Subject: planning application P/104/24/PL ambulance station, Harvest Drive Pagham

Dear Ms Riches

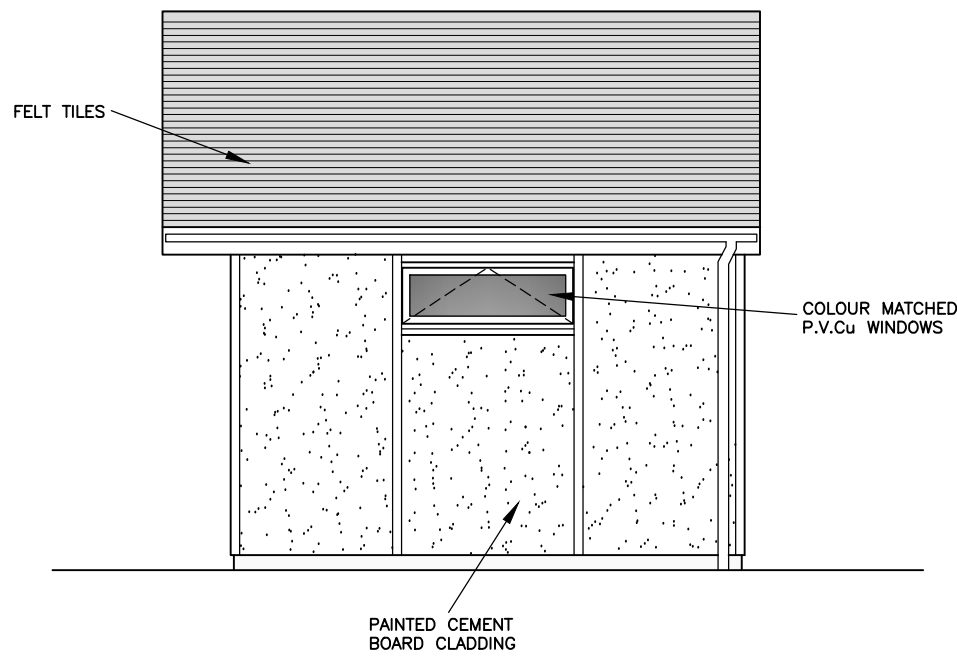
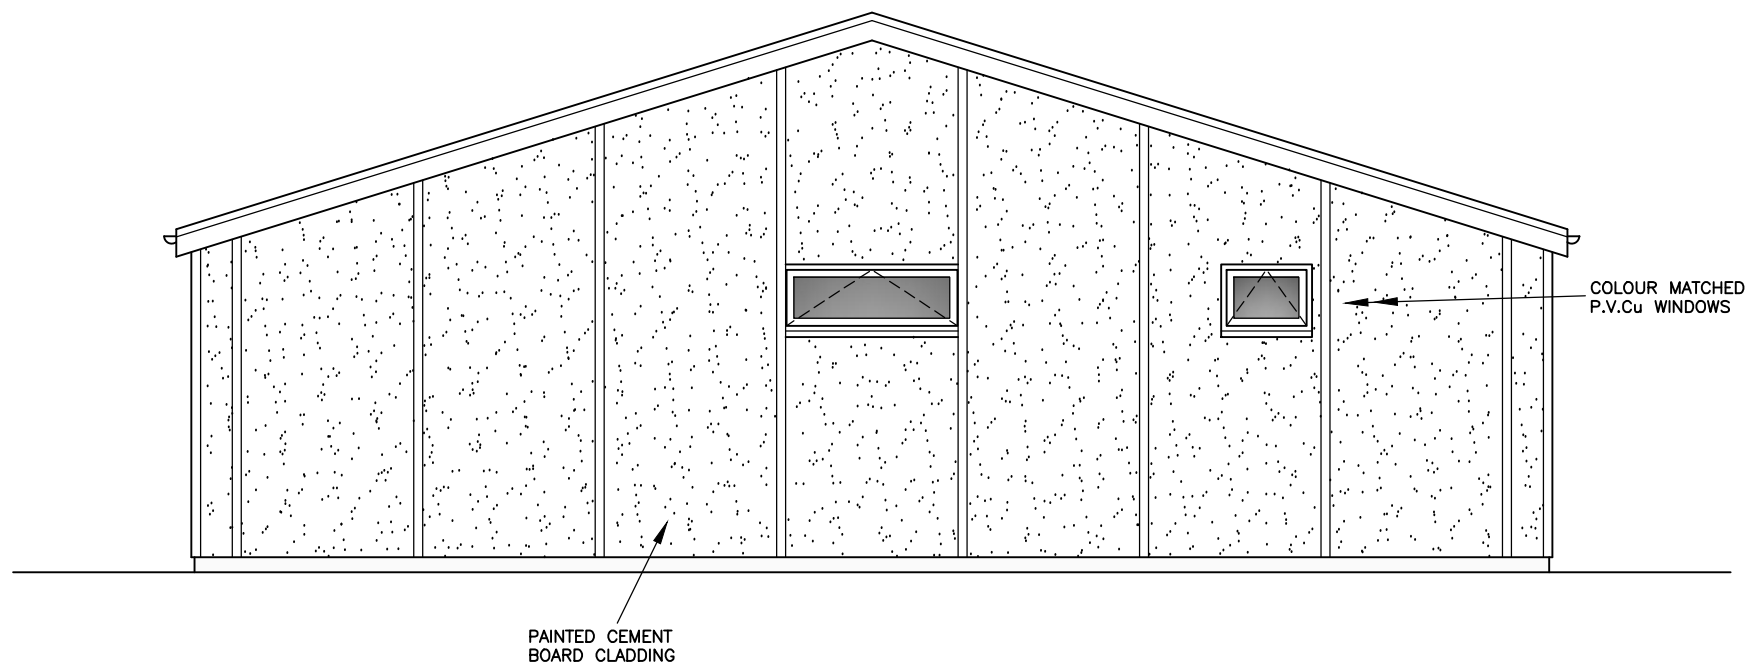
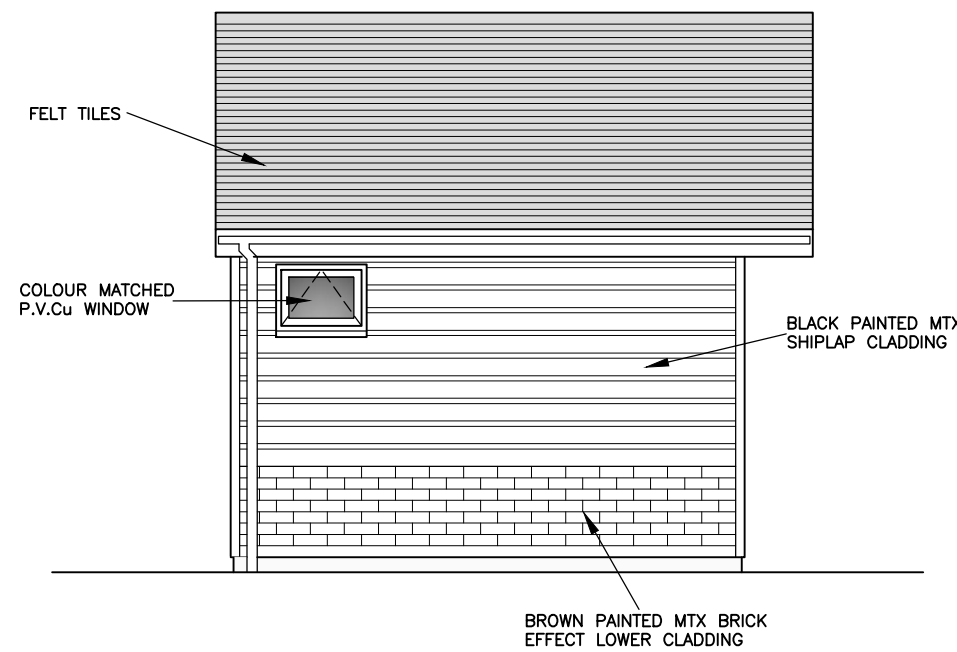
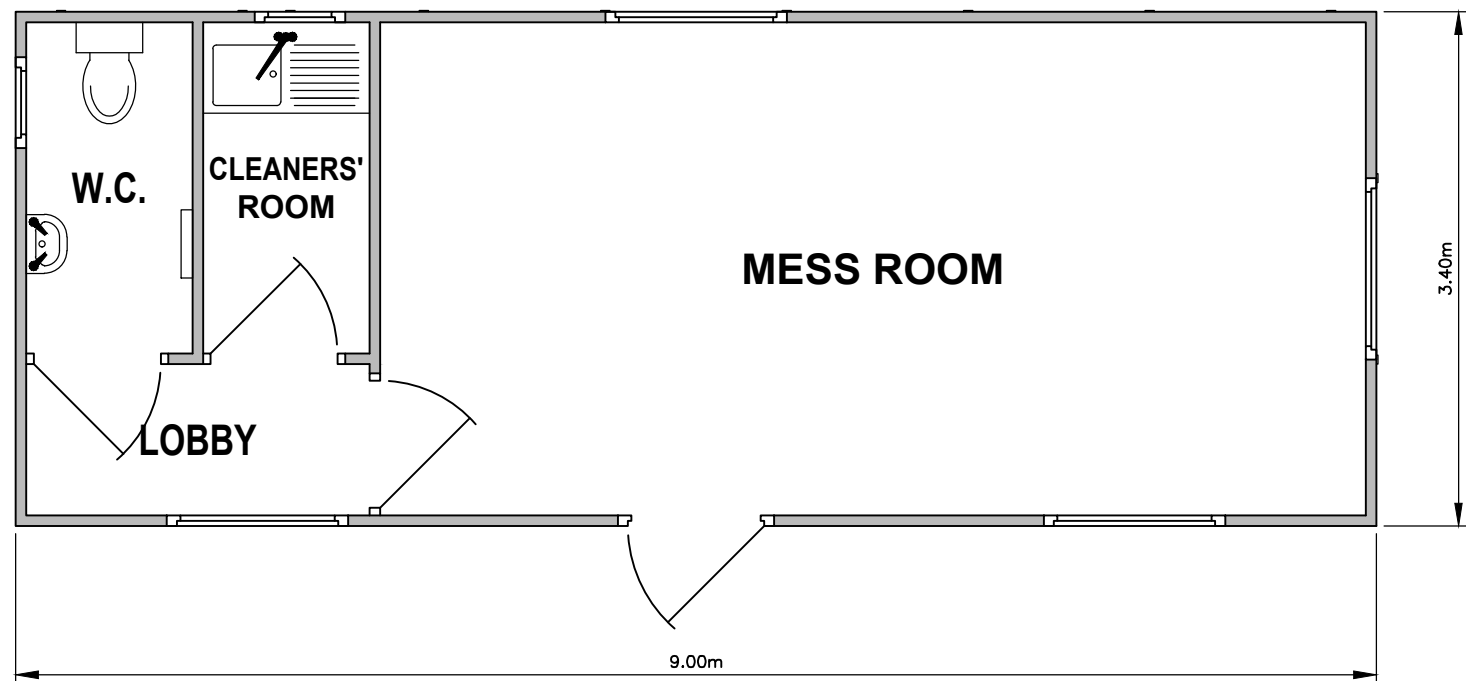
I therefore strongly request that the size of this building is reduced to a maximum of 20 sq meters and a maximum limit of one crew applied.

The building is orientated to the south away from residents opposite to give some privacy (the windows look directly onto our properties less than 30 feet away-see below). It would also give some security to the scout 'hut' and provide a better environment for users to 'relax in' being south facing.

You will notice how the proposed development impinges on our privacy, on the landscape amenity and on light levels in winter, with the low sun.

Drawing Title	SITE PLAN	Paper Size	A4
Date	July 2024	Drawing No.	5 2 4 / 0 2 2 / 9 8
			A

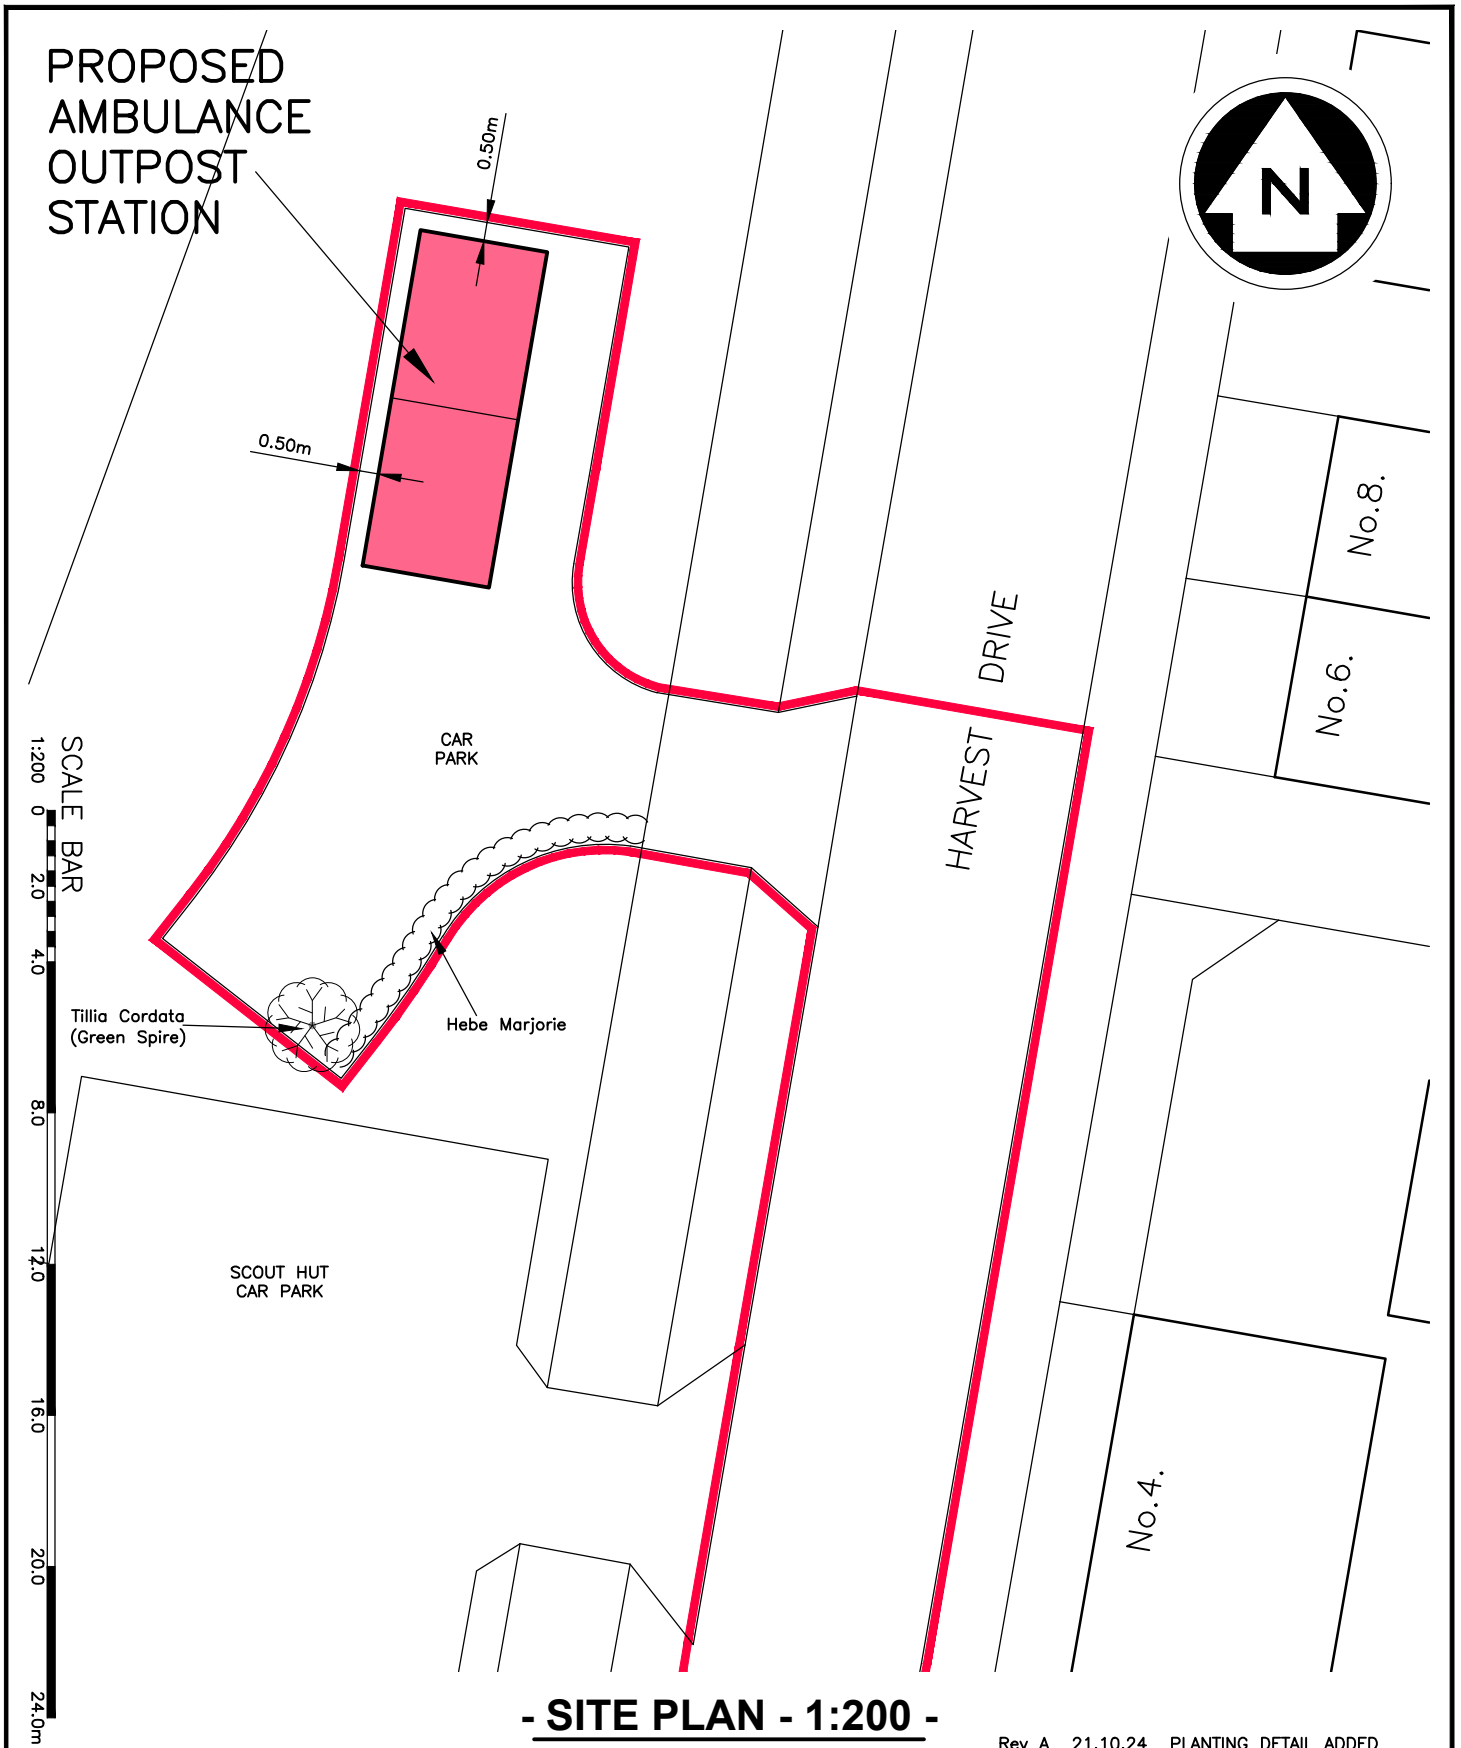
The building is screened by native trees and shrubs along Harvest drive and to the back of the building.

You will also notice the important wildlife and landscape feature of the mature treeline and hedgerow on the west of the application site which will be negatively affected by the construction, and the operation of the building.

Measures to mitigate the net biodiversity loss to this area from the building (loss of light, openness and noise/ people movement) should be added as part of the application. The existing treeline and hedgerow could be enhanced by the sympathetic planting of native species and screening planted again using native species tree and shrub species typical of clay soil.
